**COMMUNITY SERVICES DEPARTMENT**

**Subject: Lorson Ranch Sketch Plan Amendment No. 2 (SKP-19-001)**

The Planning Division of the Community Services Department has reviewed the development application for Lorson Ranch East Filing No. 3 Final Plat on behalf of El Paso County Parks. The Park Advisory Board will consider the Filing No. 3 Final Plat application on March 13, 2019 and its recommendation will be provided after the meeting.

LORSON RANCH EAST FILING NO. 3

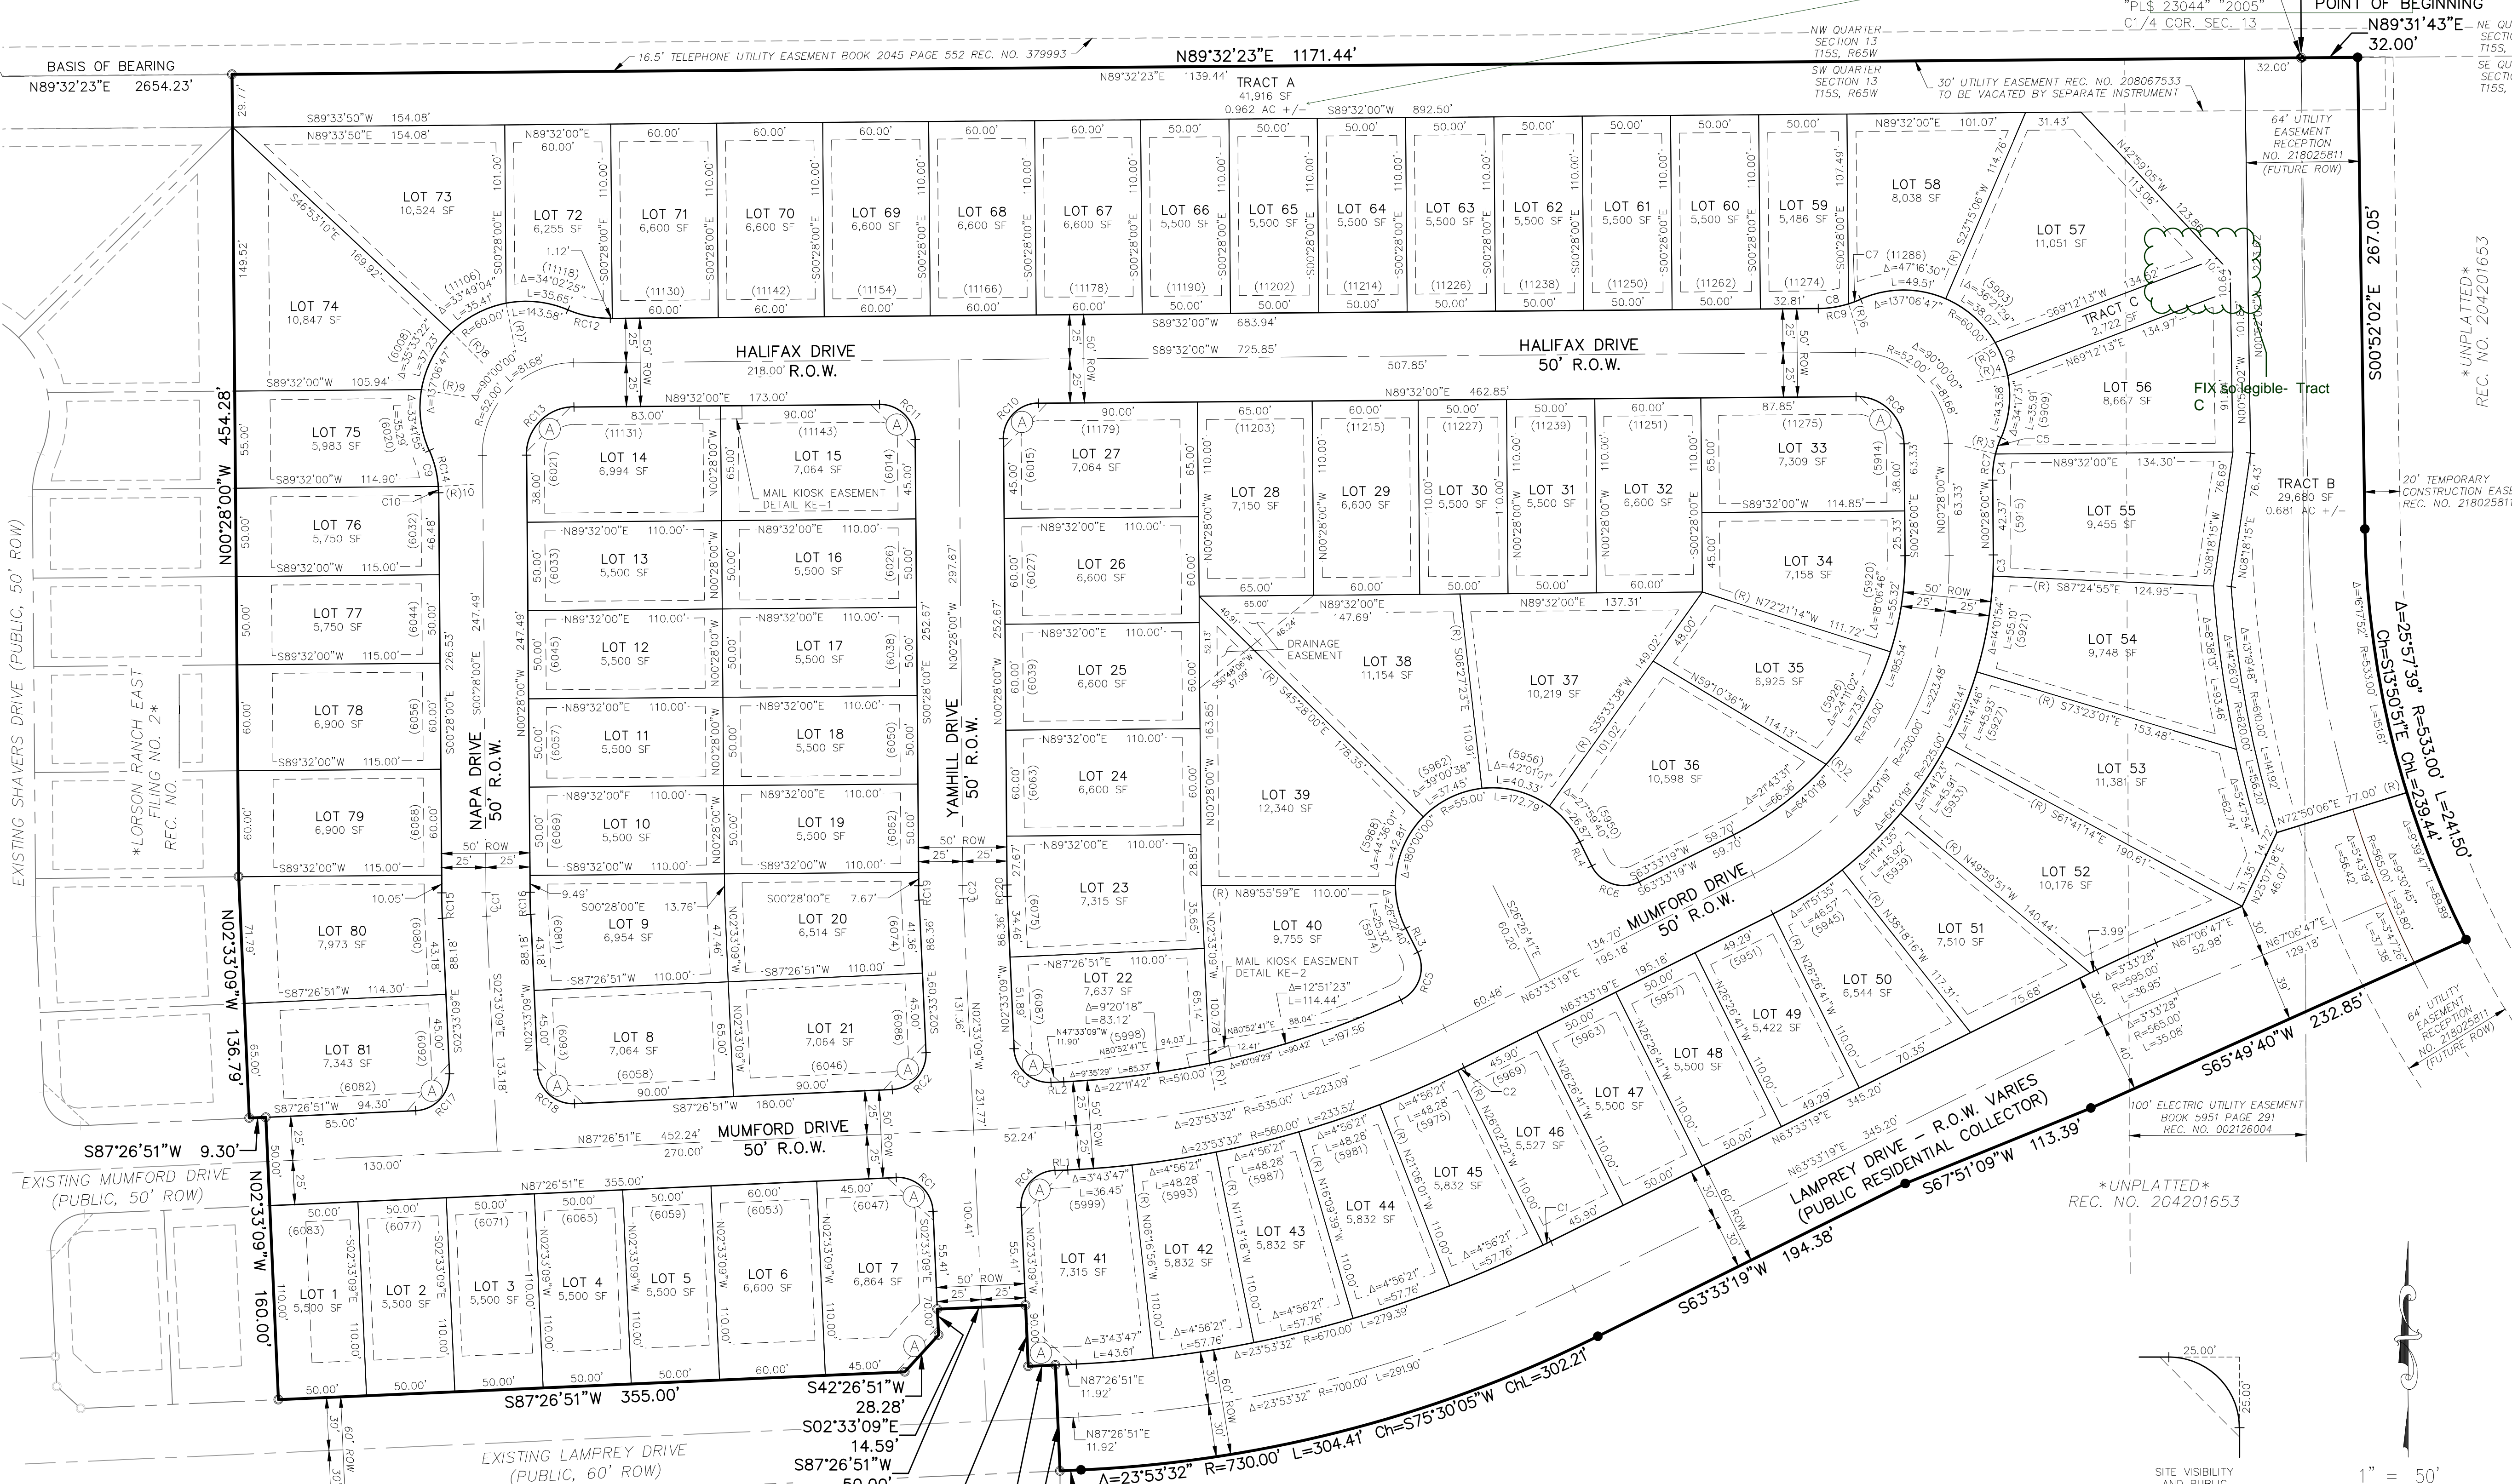
The County Parks Master Plan shows the Fontaine Boulevard Bicycle Route south of the Filing No. 3 project area along Fontaine Boulevard. This bicycle route will be accommodated within County right-of-way and installed as part of future road improvements. There are no County regional trails within Filing No. 3; however non-County trails were shown on the previously approved PUD and Preliminary Plan drawings which Filing No. 3 is contained within. The Filing No. 3 final plat drawings are missing previously included non-County trails shown on the approved PUD and Preliminary Plan drawings. This includes a trail along the northern boundary within Tract A. Please show the non-County trails on the final plat drawings.

*Recommend to the Planning Commission and Board of County Commissioners that approval of Lorson Ranch East Filing No. 3 Final Plat include the following conditions: (1) Show non-County trails within Tract A on the final plat drawings consistent with the previously approved PUD Development and Preliminary plan (2) require fees in lieu of land for regional purposes in the amount of \$36,936 and urban fees in the amount of \$23,328. A park lands agreement may be an acceptable alternative to urban park fees provided the agreement is approved by the County and executed prior to recording the final plat.*
